Planning Application No: 3/2026/0603

Proposal: Permission in principle application for two detached dwellings.

Location: Land adjacent to Fernhill, Ribchester Road, Clayton le Dale BB1 9EG

PROPOSED SITE PLAN
(Illustrative only)

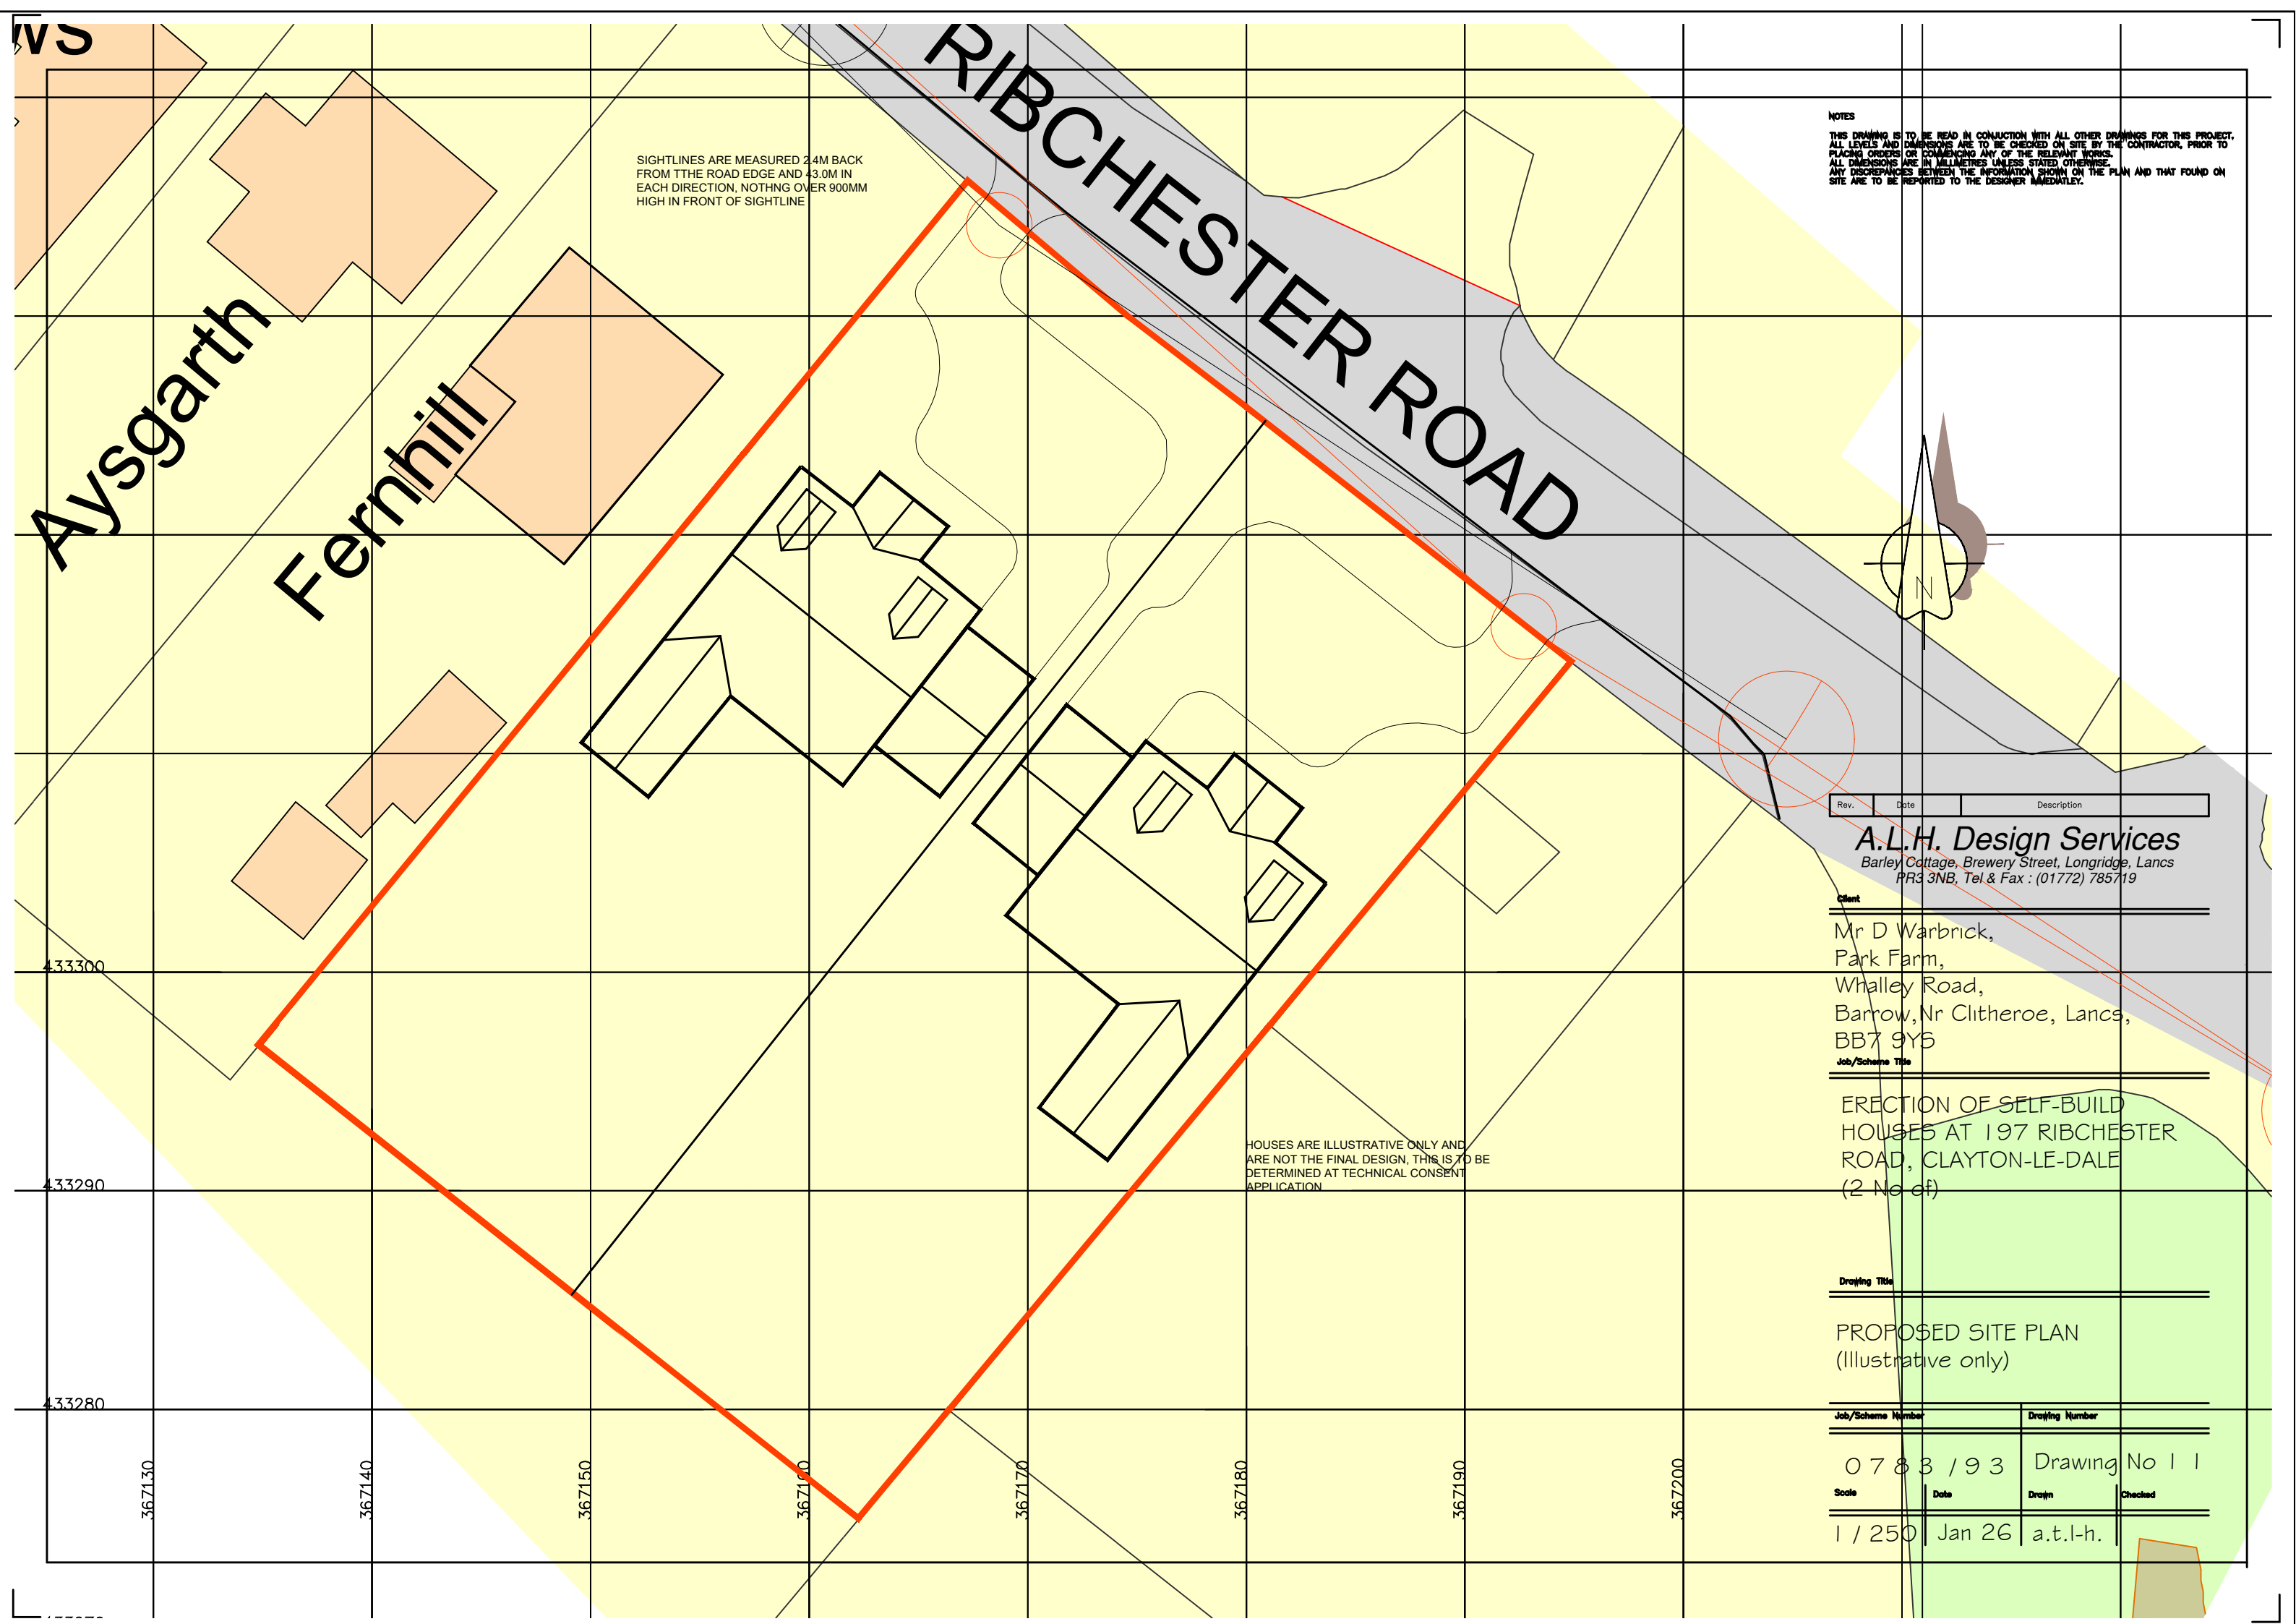
A Proposed Site Plan (Drawing 11) has been submitted. However, as the principle of development only is being applied for the highway authority considers the layout as indicative only.

Based on the above criteria, and the indicative Proposed Site Plan submitted, the highway considers that adequate visibility splays cannot be achieved, with splays from both access points being over third party land and hence out of their control. Unless and until adequate visibility splays have been demonstrated from the site, which may require the access points being re-located, the highway authority will object to any application.

Two new vehicle access points are proposed from the site onto Ribchester Road. Site plans will be required based on measurements taken on site and not based on the OS layer. The Proposed Site Plans submitted (Drawings 06A and 11) show a footway/verge of up to 2m wide across the site frontage. The revised plans must show the correct width

of the service verge, which is narrower. Plans must also show the locations of highway gullies and street lighting columns across the site frontage and immediately adjacent.
